WSCC Highways Pre-Application Responses

**WEST SUSSEX COUNTY COUNCIL
PRE-APPLICATION CONSULTATION**

TO:	Organisation: Highgate Transportation FAO: Alice Howse and Fiona Bennett
FROM:	WSCC - Highway Authority
DATE:	20 October 2025
LOCATION:	Land North of Summer Lane Summer Lane Pagham PO21 4FE
SUBJECT:	Internal Reference: PRE-80-25 Circa 110 residential dwellings on Land to the North of Summer Lane, with circa 50 dwellings to be accessed via Summer Lane, and circa 60 dwellings to be accessed via the recently approved site P/35/24/OUT
DATE OF SITE VISIT:	15 September 2025
RECOMMENDATION:	Advice
S106 CONTRIBUTION TOTAL:	TBA at planning application stage

Fig. 1

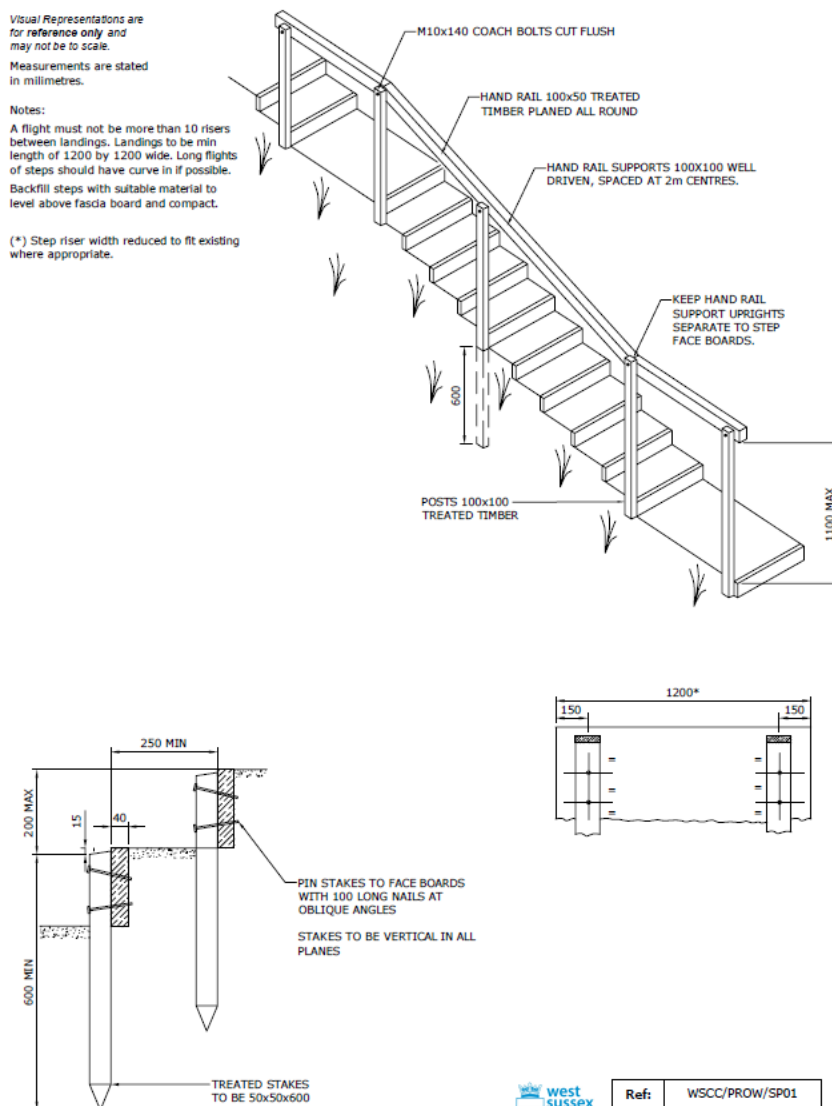
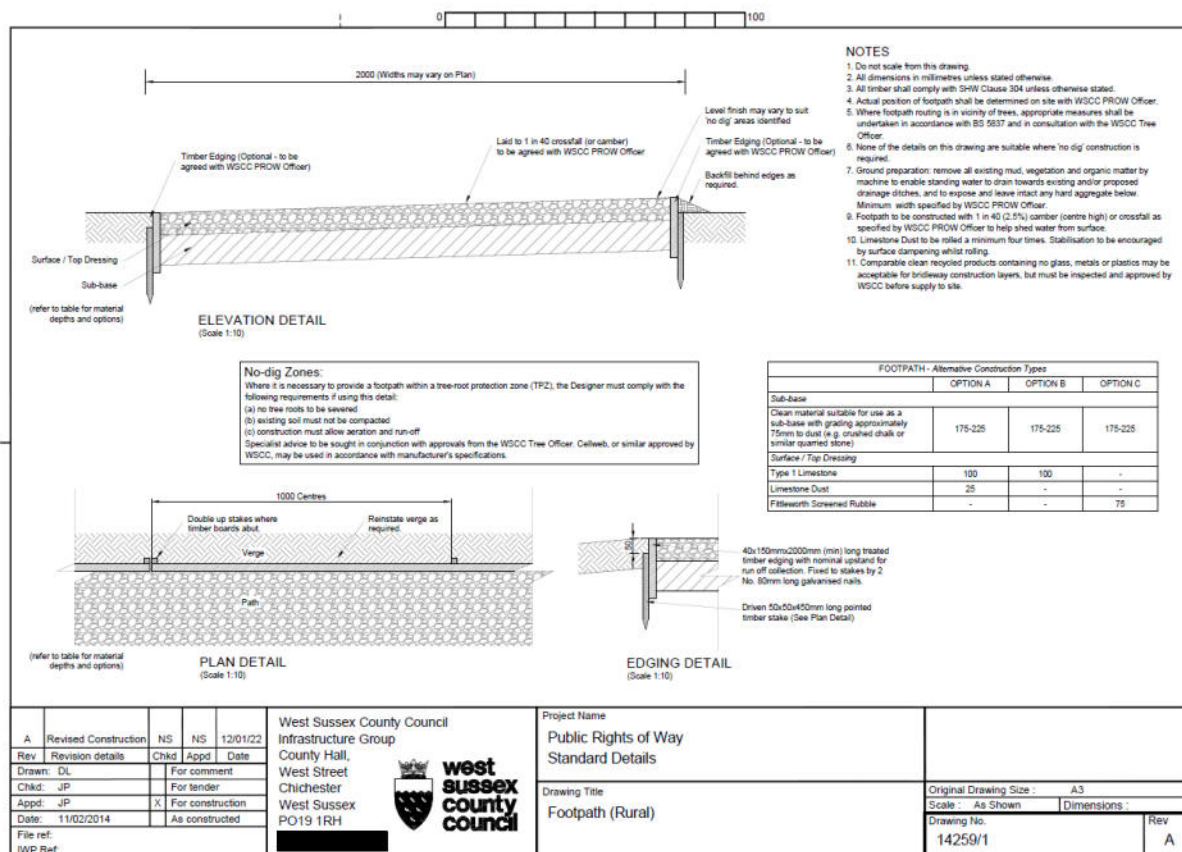
- 6. The stepped and ramped access from Summer Lane onto Footpath 108 is welcome. The ramp would not form part of the PRoW so maintenance liability would remain that of the developer whereas the stepped access would be part of the PRoW as it would be along the definitive line and provides sufficient access for pedestrians. There would, however, need to be agreement as to details of materials and construction with PRoW team although the structure itself might still need to remain private.*

- 7. Footpath 108 crosses through a green area within the development and should have its' surface improved to the PRow rural footpath specification up to the red line boundary.*
